From: Zac Denton <Zac.Denton@arun.gov.uk>
Sent: 24 July 2020 07:18
To: Planning.Responses <Planning.Responses@arun.gov.uk>
Subject: FW: Planning Consultation on: K/19/20/HH

Application No:	K/19/20/HH
Registered:	18th June 2020
Site Address:	99 Golden Avenue East Preston BN16 1QT
Grid Reference:	507814 101785
Description of Works:	First floor walls of existing dwelling to be finished with Hardie cladding in lieu of existing tile hanging. First floor and pitched roof added to garage with external staircase to rear.

Drawing: **EXISTING & PROPOSED - GARAGE**

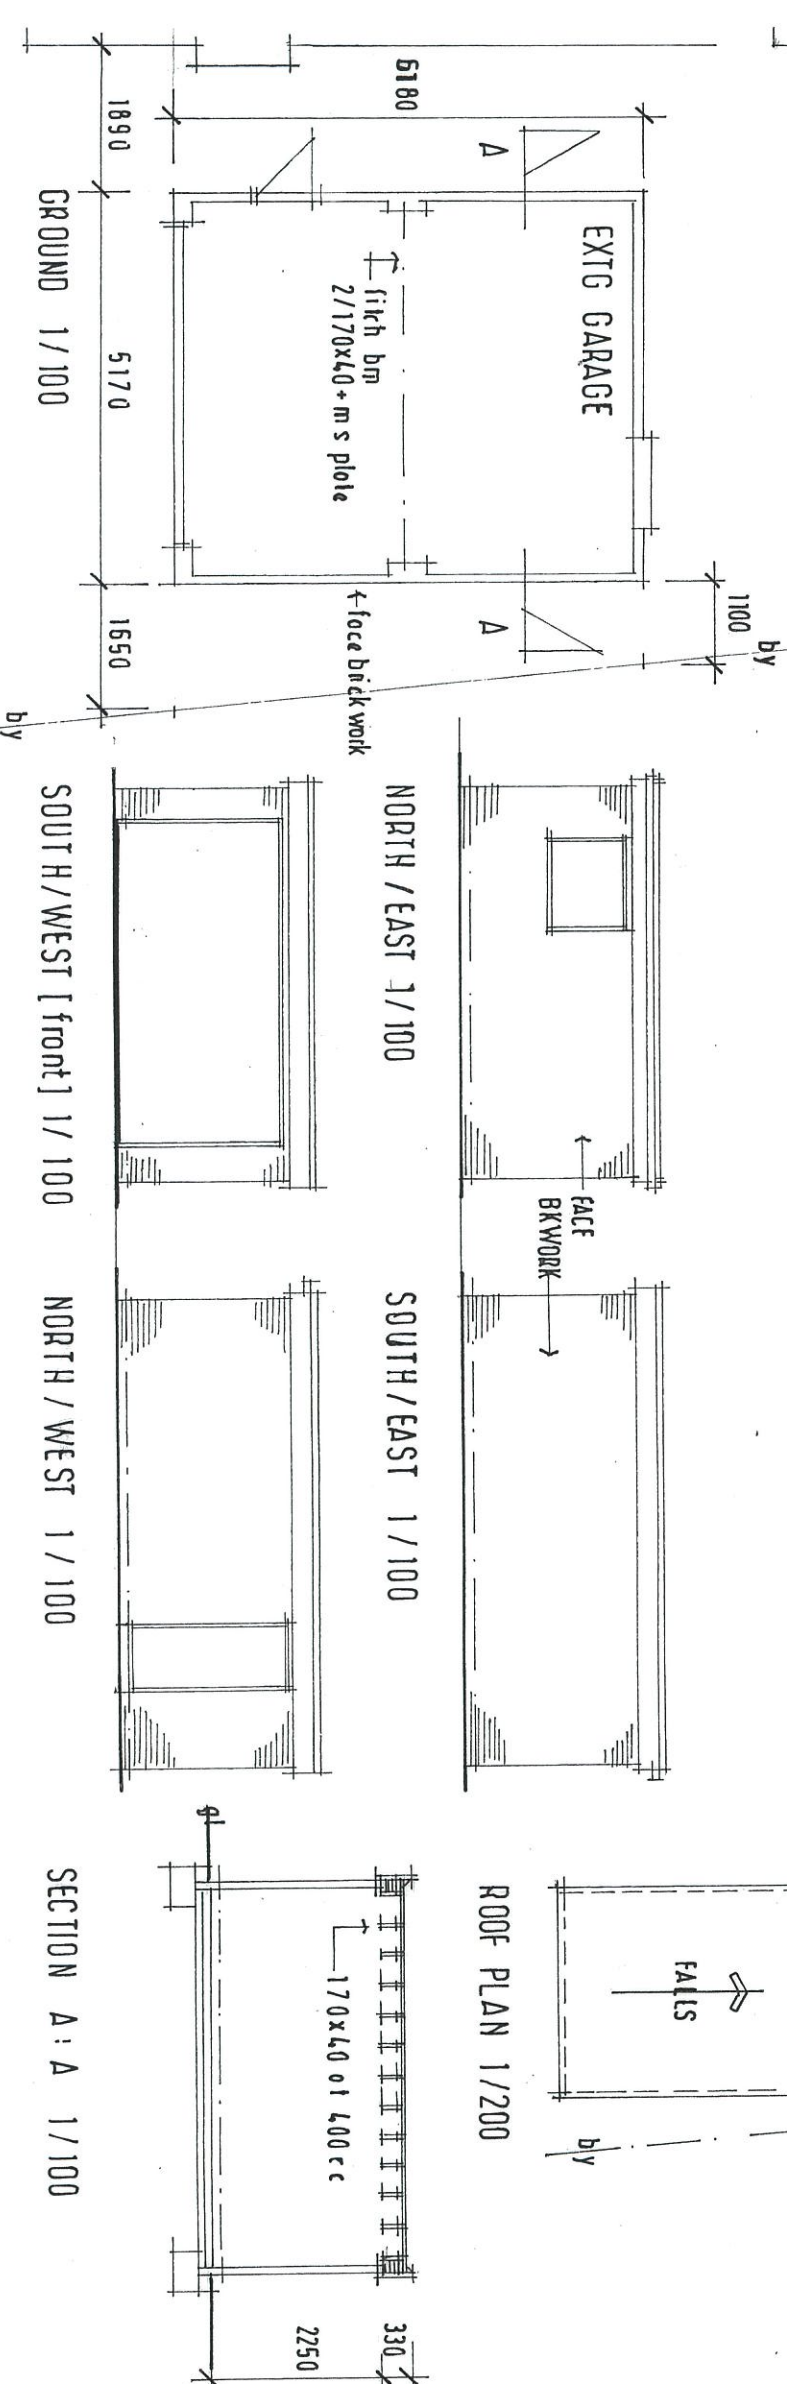
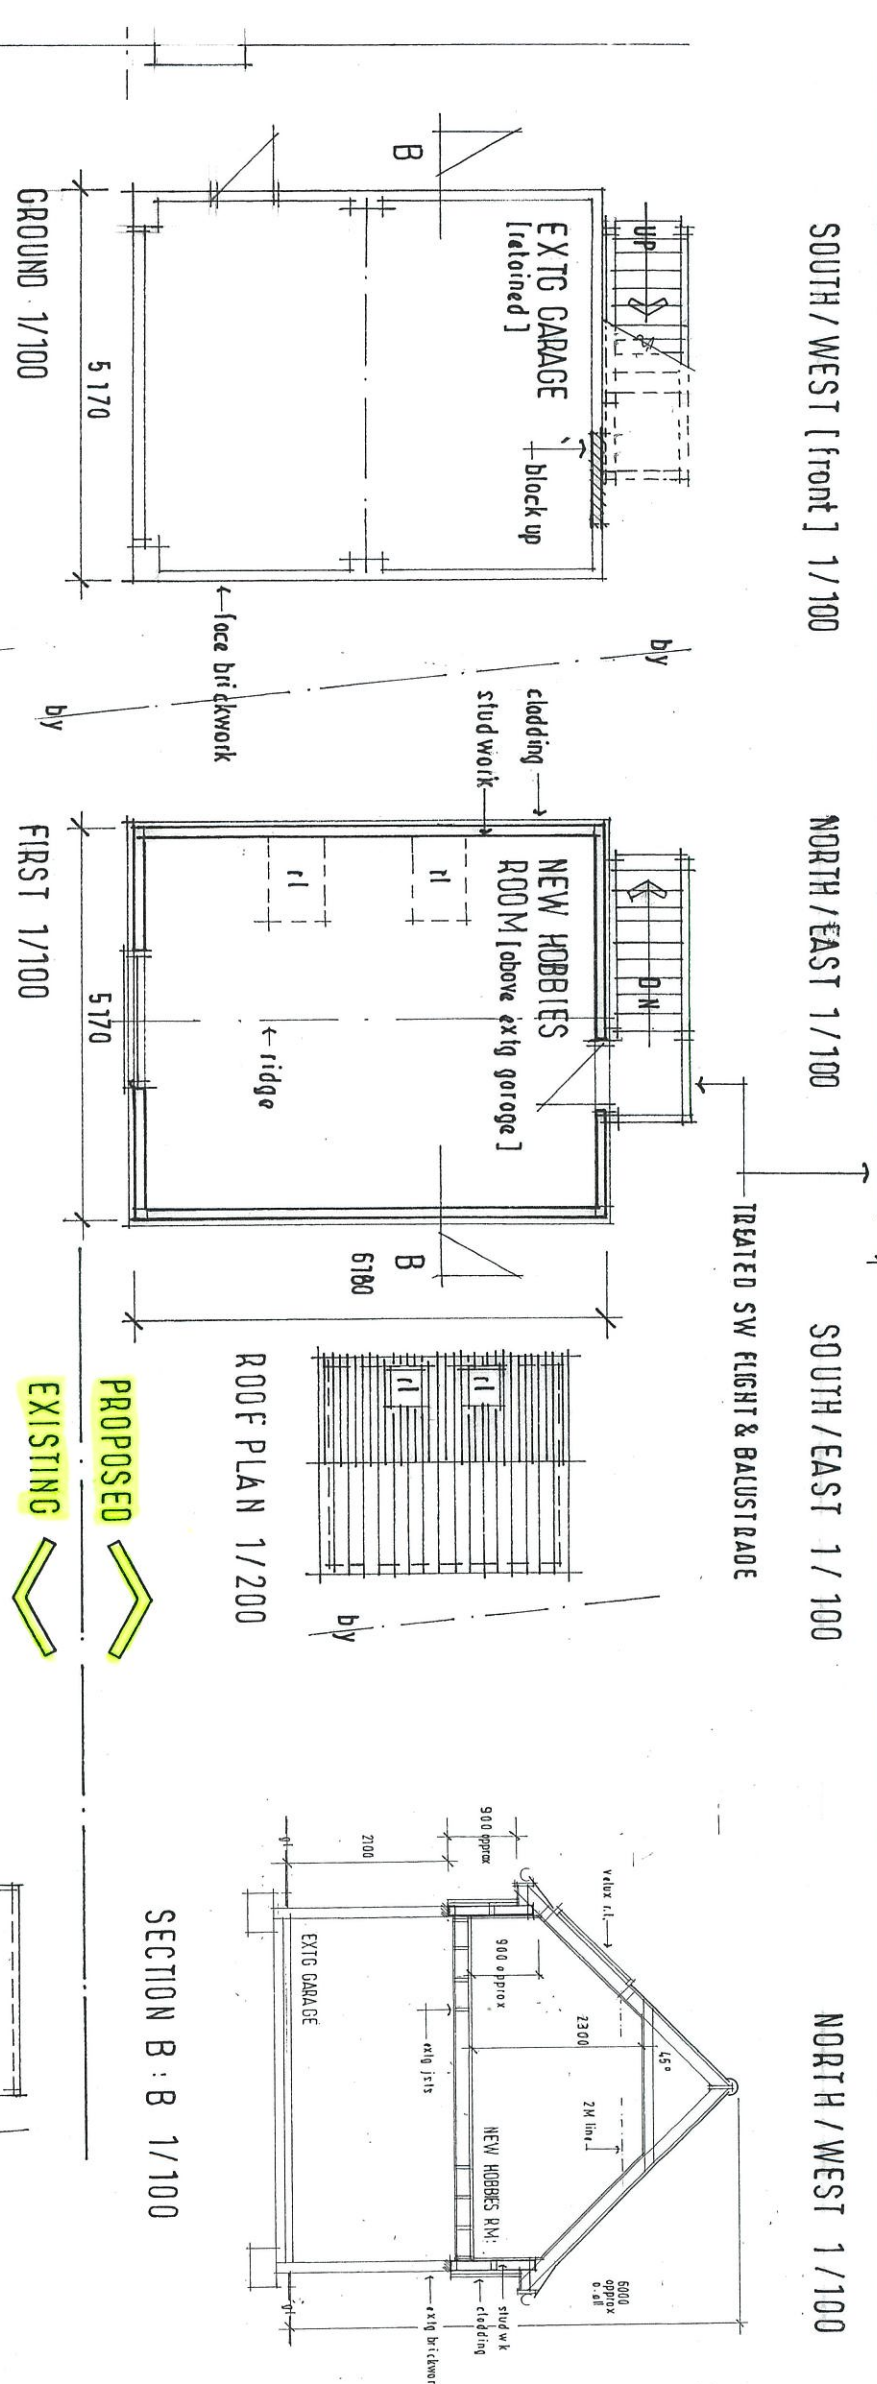
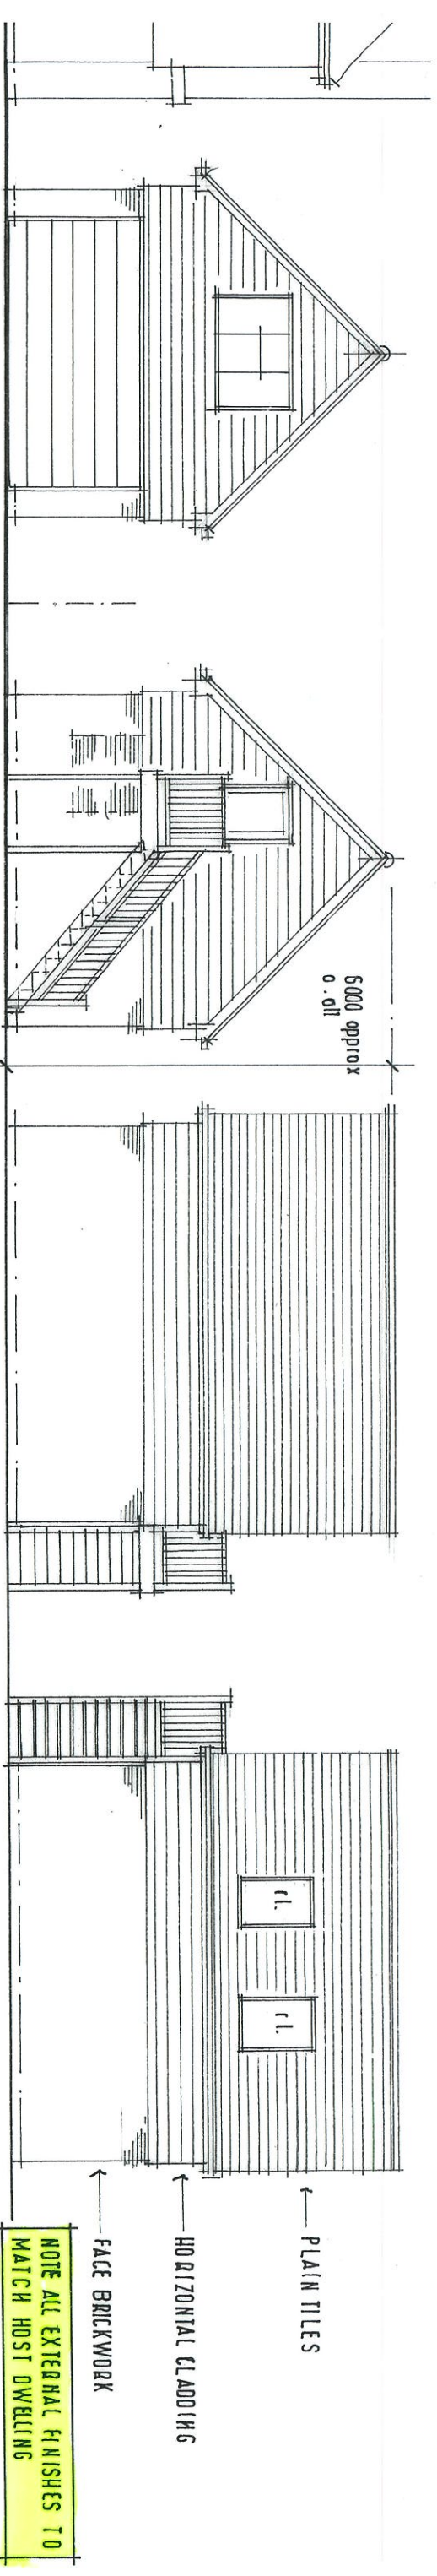
No Objection as long as the case officer is satisfied that:

- the external staircase to the first floor of the garage is not intrusive to the privacy of neighbouring properties
- the proposed increase in size and height to the garage is not out of scale to the main dwelling and does not adversely affect the street scene
